SCOPING OPINION

Proposed International Advanced Manufacturing Park (IAMP)

Planning Inspectorate Reference: BC030001

September 2016

Indicative Masterplan

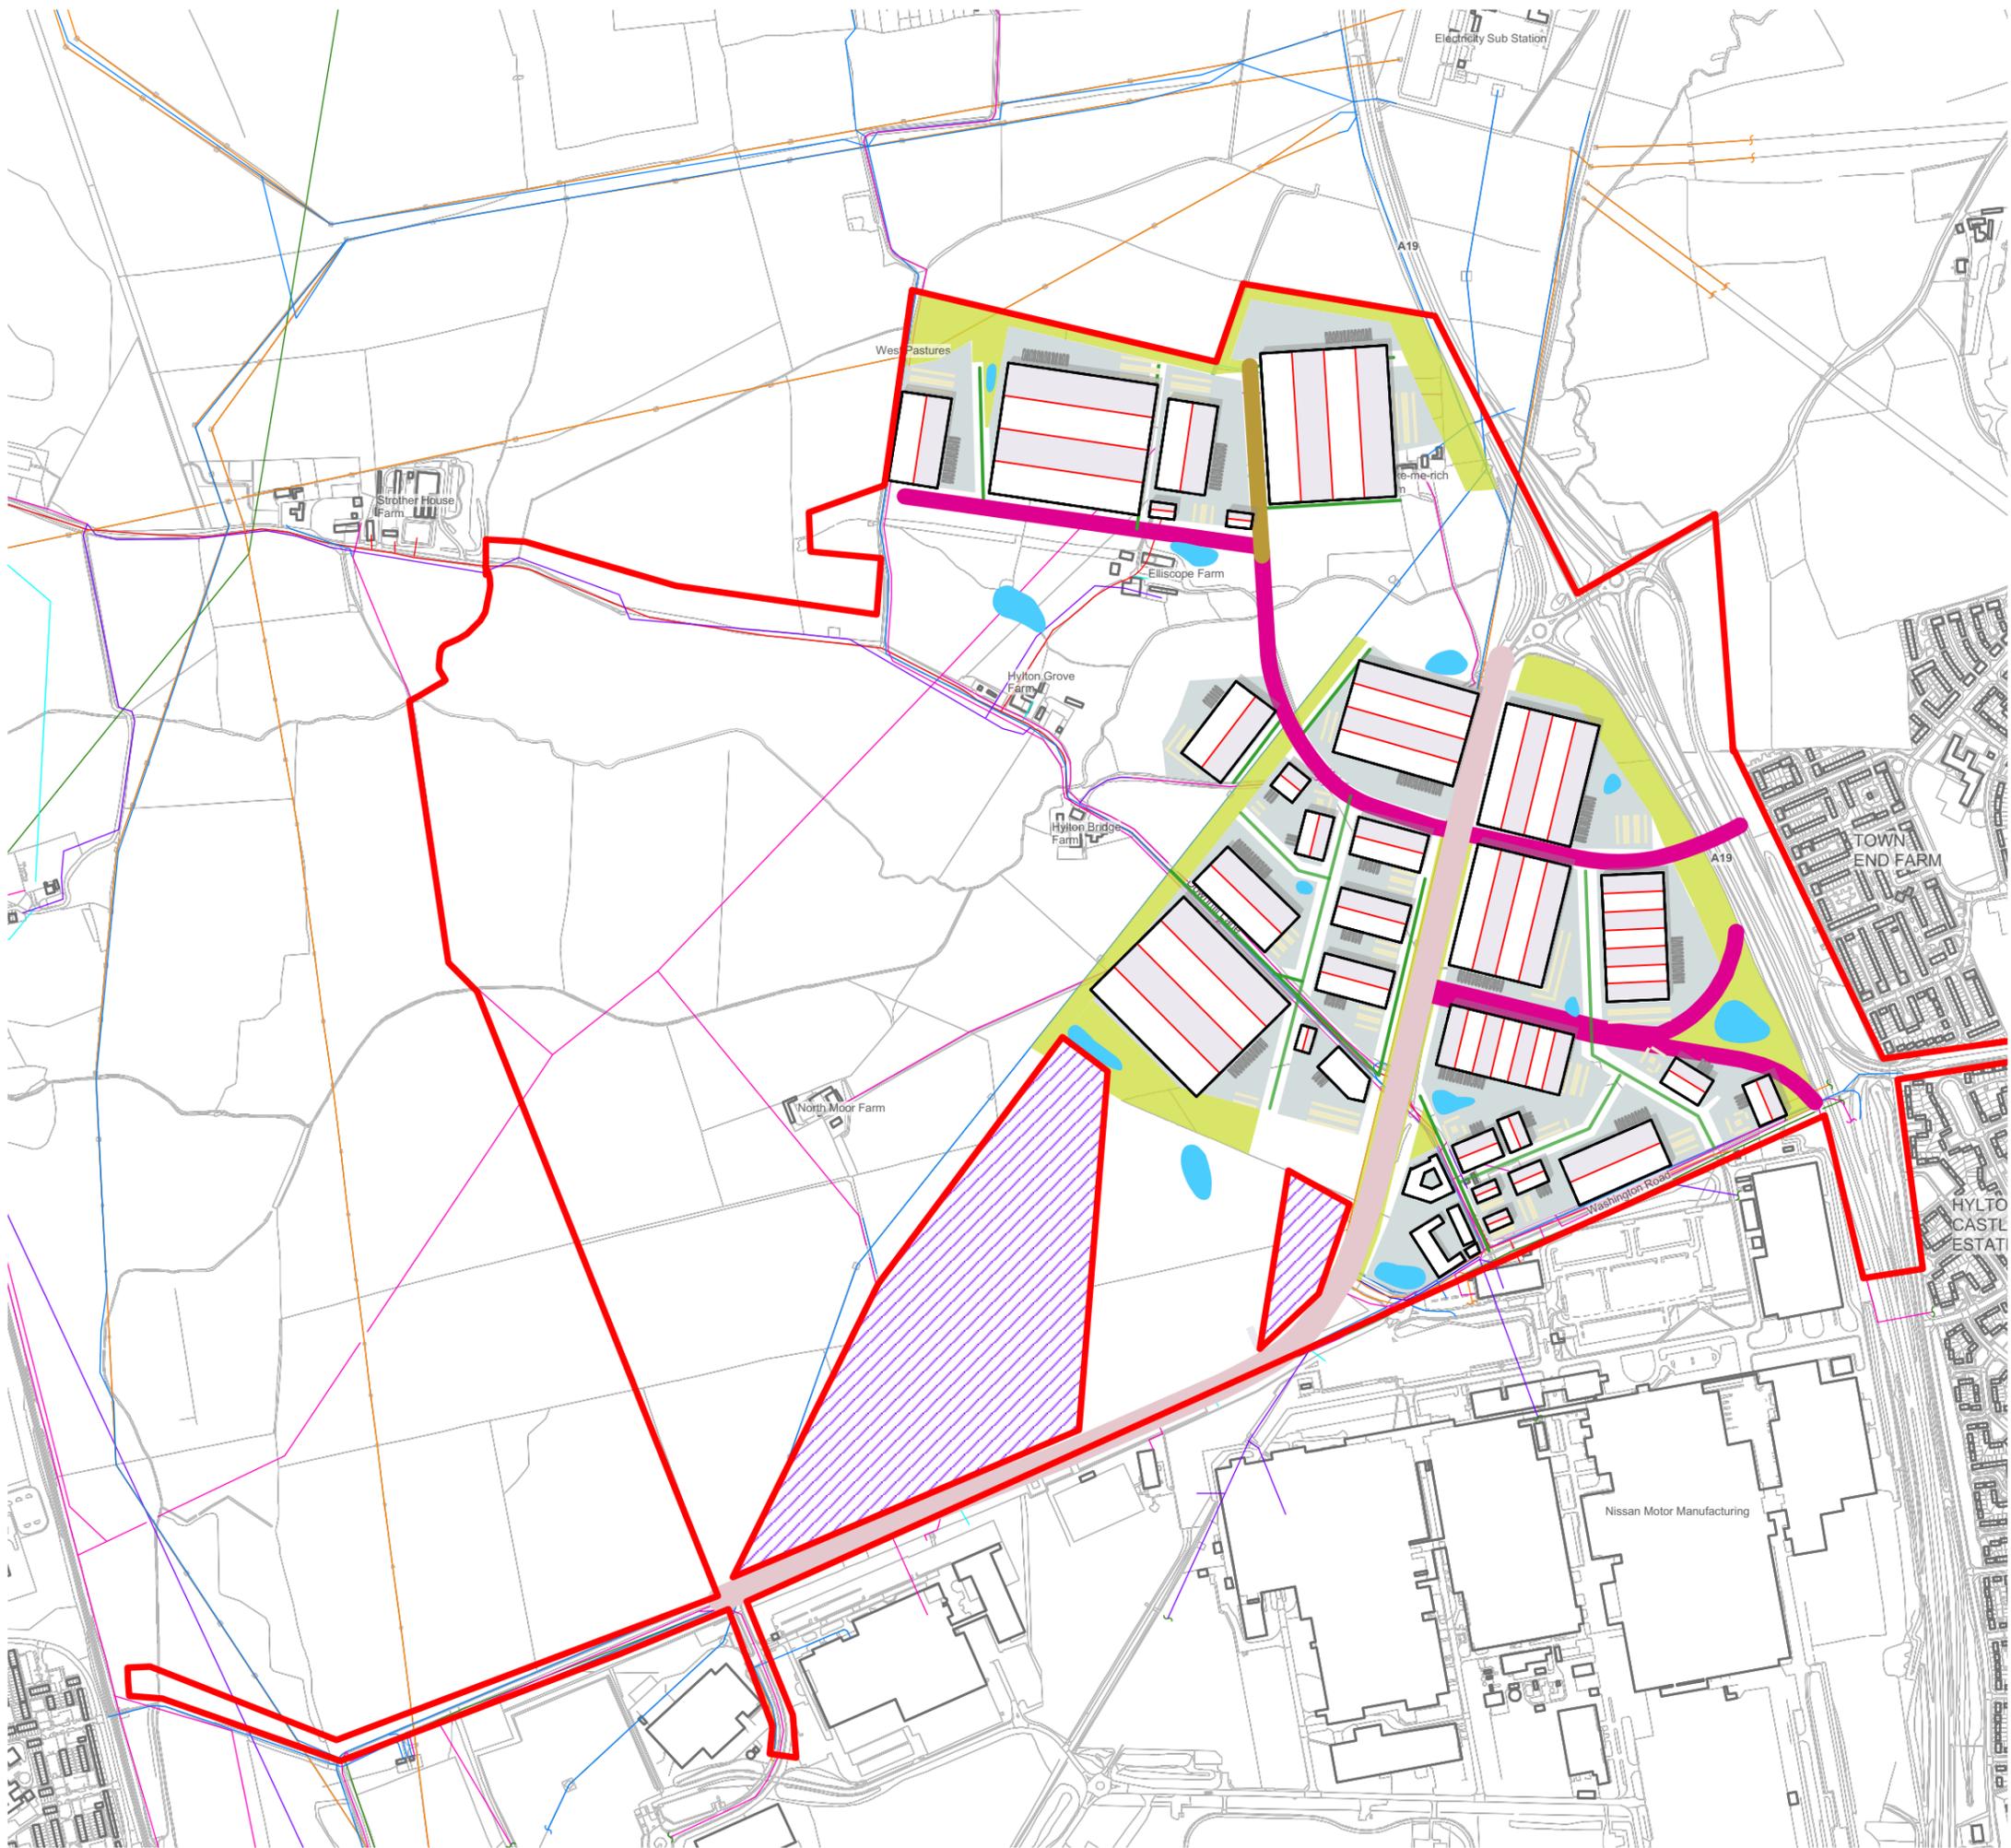
- 2.44 There are a number of areas within the application site boundary which appear to be 'empty' i.e. without any development taking place according to the proposed masterplan (Appendix D of the Scoping Report). The Secretary of State notes that these areas primarily comprise the "ecological and landscape mitigation area" (as described at section 2.9.3), the ES should explain and illustrate the need for all land included within the application site boundary. It is assumed that the reason the areas are empty at present is because specific mitigation details remain to be agreed and refined with relevant stakeholders. If this land is relied upon as mitigation for the purposes of the assessment sufficient detail should be provided in order to demonstrate its efficacy.

- Emissions- water, air and soil pollution, noise, vibration, light, heat, radiation.
- 2.52 Appendix D of the Scoping Report identifies on the masterplan what appear to be ponds or otherwise small bodies of water. There is limited detail at this stage regarding the design of these features. The Secretary of State would expect the description of the proposed development to be sufficiently detailed so as to describe the volume of attenuation required and the associated land take for natural and or engineered drainage attenuation features. This aspect is discussed further in Section 3 of this Scoping Opinion.

Constraints Plan

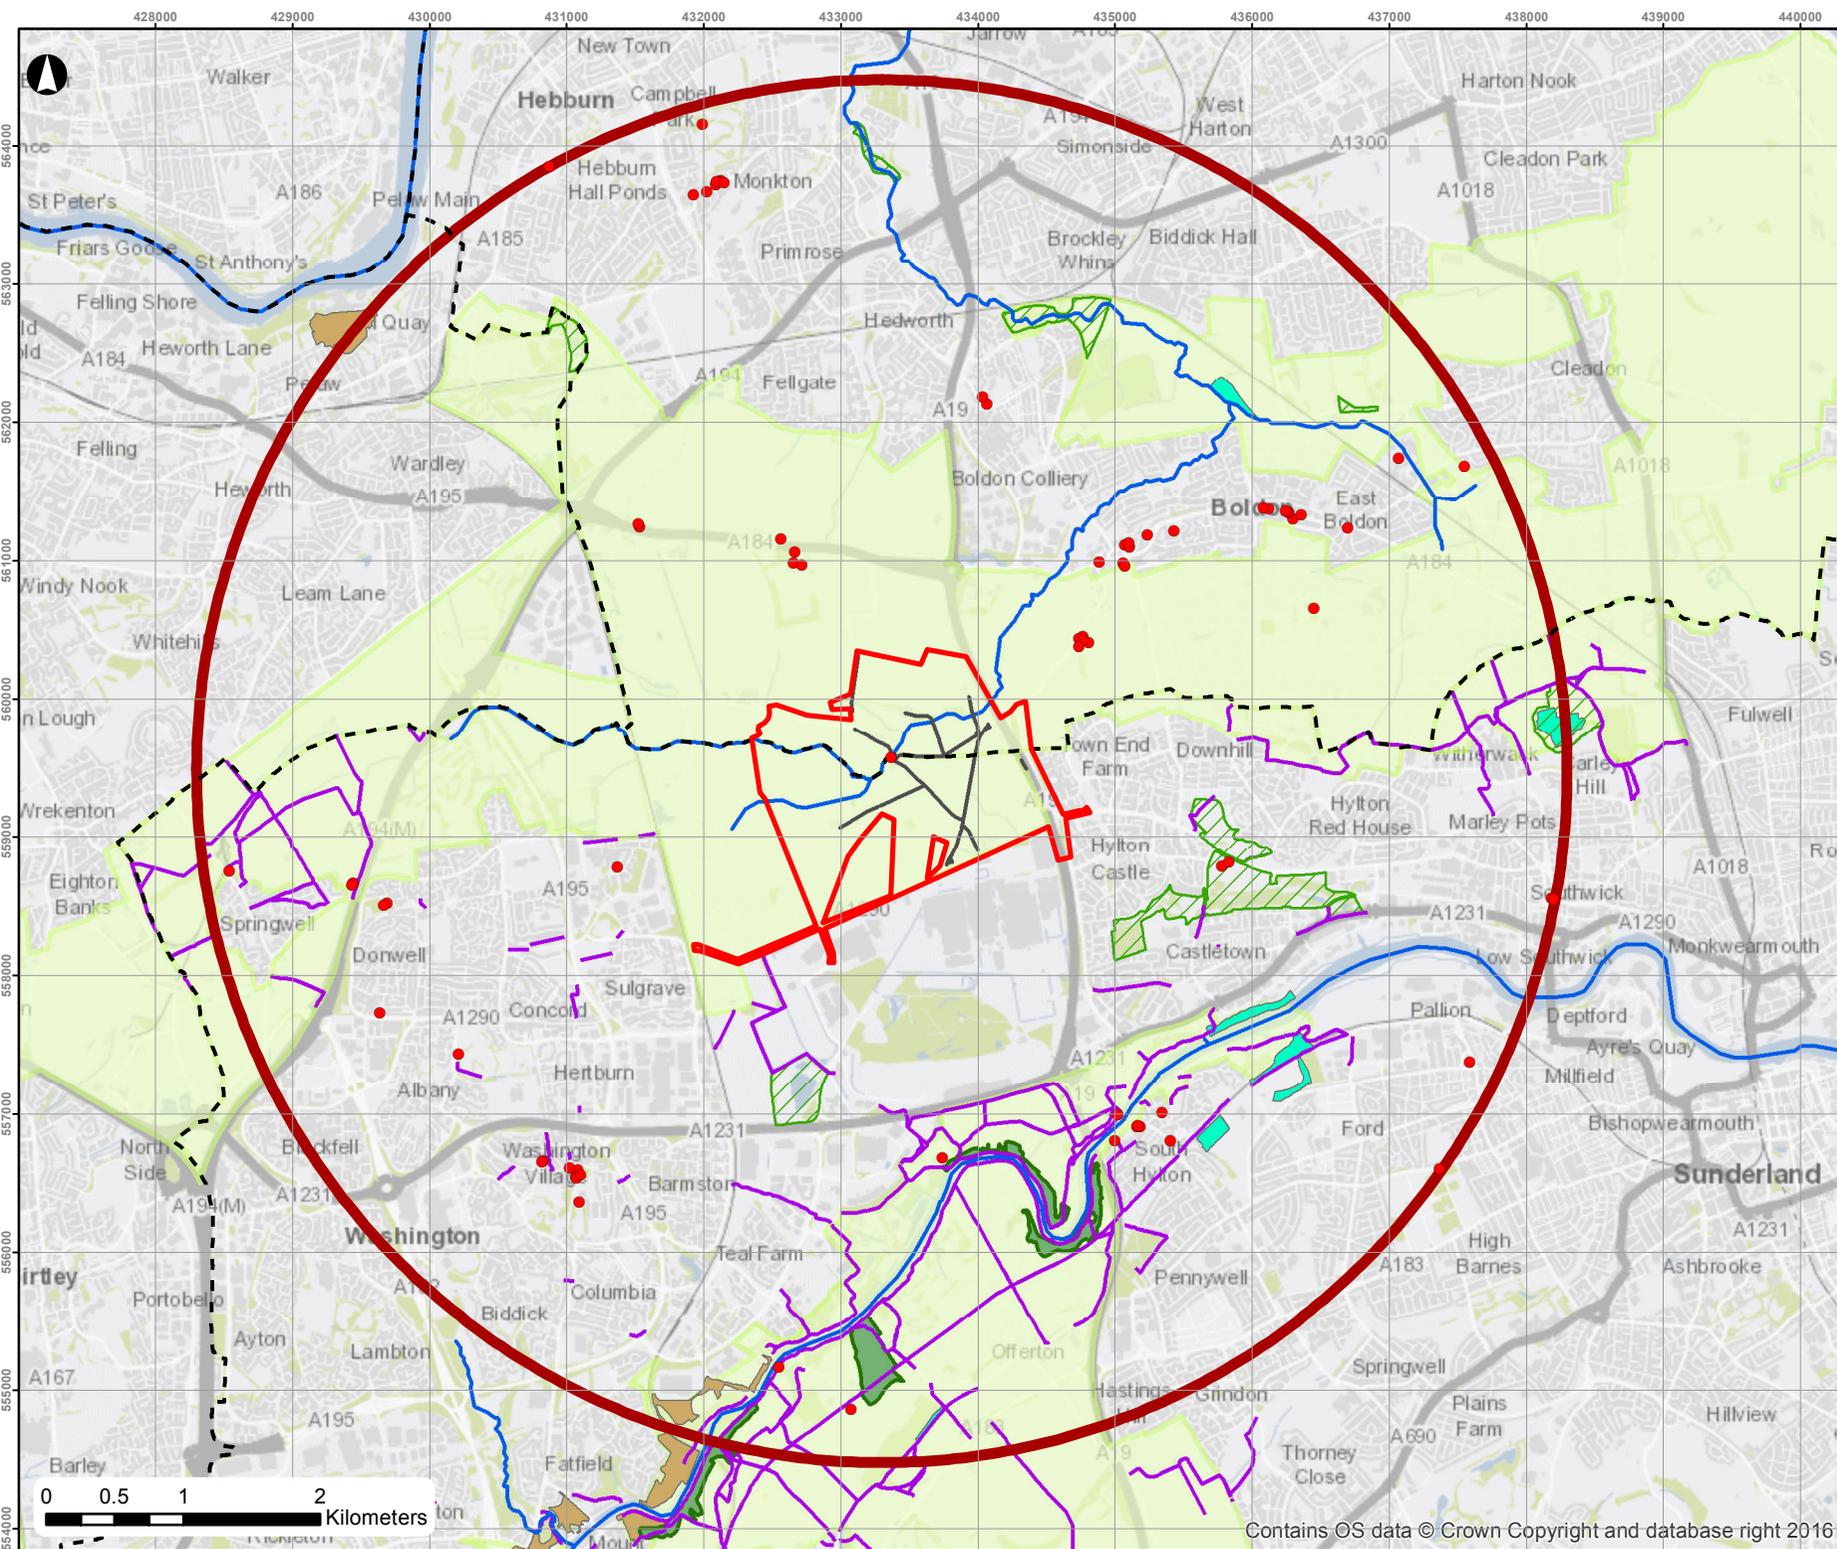
- 2.39 The Secretary of State notes that the AAP process is entirely separate to that of the DCO application for the proposed development and that both SCC and STC are undertaking formal public consultation on the publication of the draft joint AAP at the time of preparing this Scoping Opinion. The Applicant's attention is drawn to Gateshead's comments regarding greenbelt boundaries.
